From: Sue Howell
Sent: 27 June 2017 12:10
To: Planning.Responses
Cc: Anita Gardner; Rachel Alderson
Subject: RE: Planning Consultation on LU/177/17/DOC

Condition 3 Landscaping scheme – Further to submission of DWG No 5312-LC-100 Landscape Masterplan, DWG No 5312-LC-401/405 It would be recommended that some minor amendment is made and further detail is provided.

Site Address: Littlehampton Swimming & Sports Centre Sea Road Littlehampton BN16 2NA

Description of Works: Application for approval of details reserved by condition imposed under planning permission LU/314/16/PL relating to condition No. 3 (Landscaping scheme), 4 (Habitat mitigation strategy), 6 (Foul & Surface water sewerage disposal), 10 (Details of plant & equipment), 14 (Details of kitchen extract system & type of cooking to be undertaken in the facility) & 15 (External lightings scheme)

DWG. NO 5312_LC_102_REVA

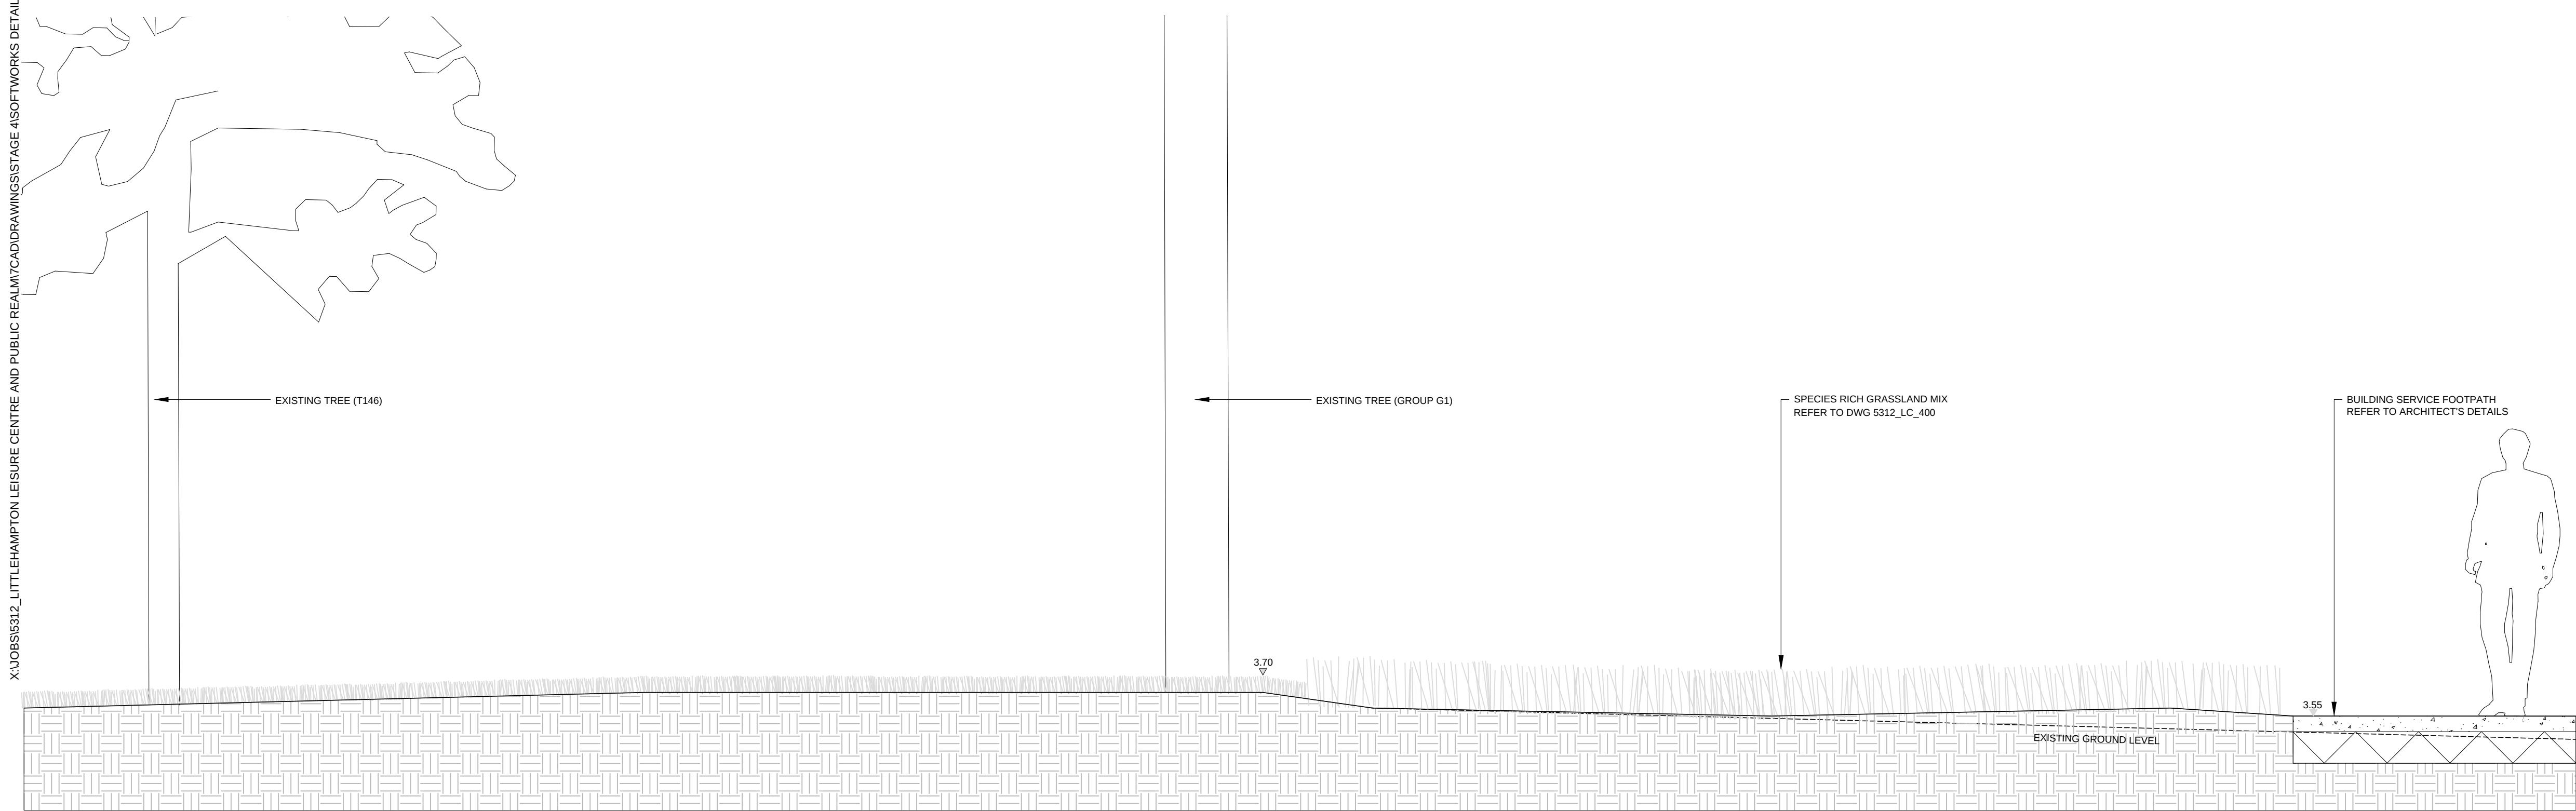
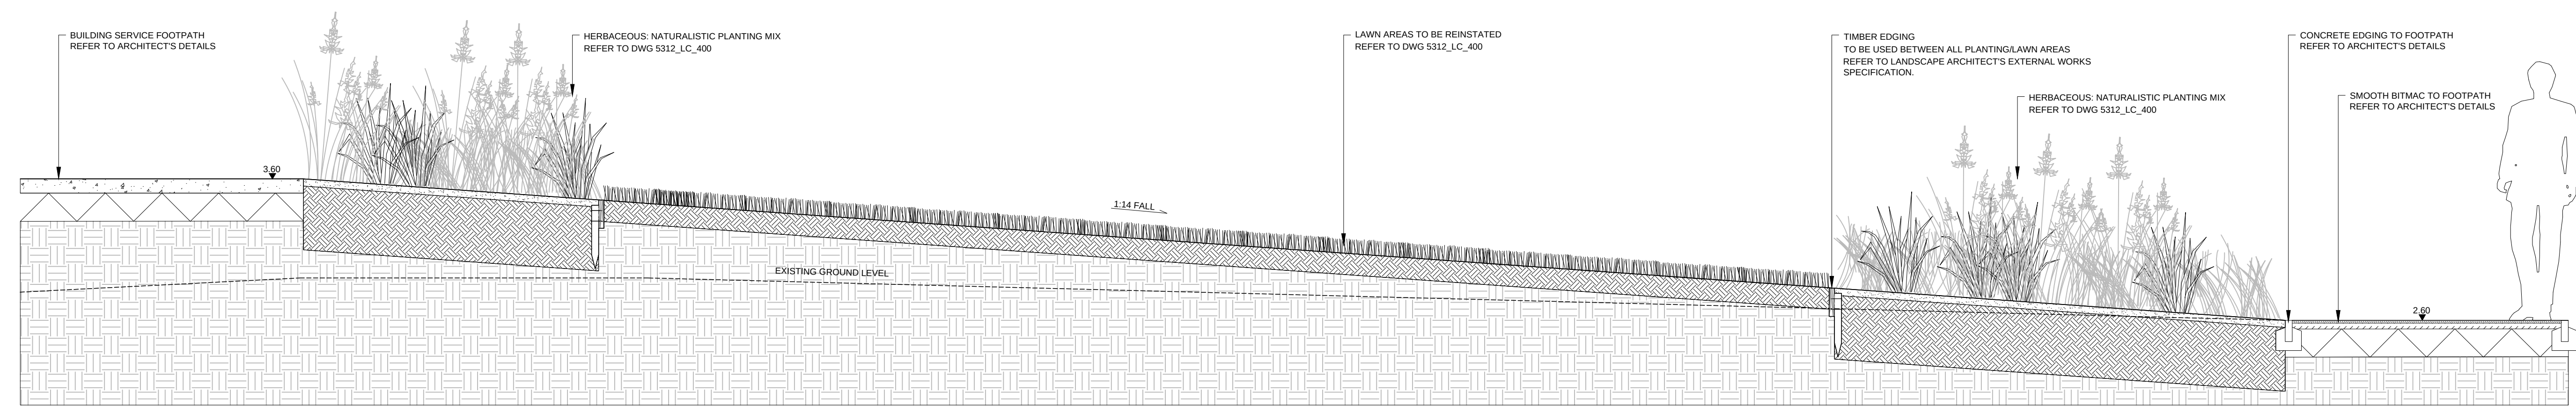
- There is an area identified on the layout plan as species rich grassland mix however this is not further detailed on the detail plans. Clarification would be sought regarding the specification of this.

DWG. NO 5312_LC_403_REVA

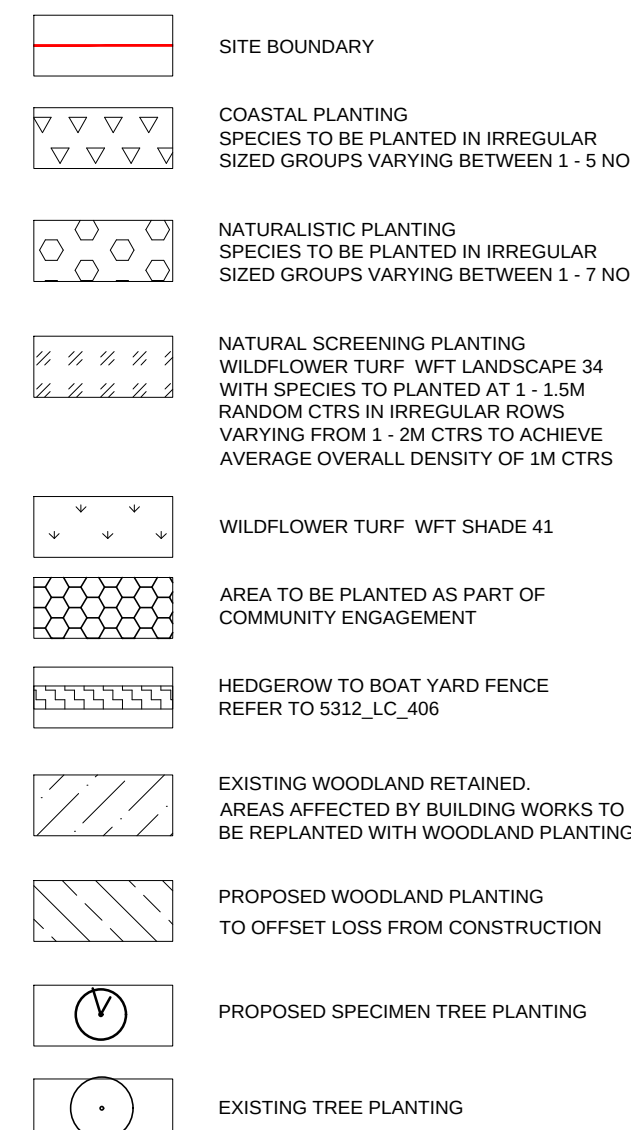
- The tree species choice of Betula Pendula in close proximity to Sea Road and Hendon Avenue would be questionable in this full exposure location. Whilst Pinus radiata should be capable of establishing in such a marine exposed site, Betula may struggle in this location and would therefore have to recommend that this species choice is reconsidered.

- The Ecological review of Landscape Strategy states 'loss of mixed woodland is temporary and will be compensated through additional woodland planting along the east boundary of the site' It is unclear where this planting is; as planting to eastern boundary is not detailed?
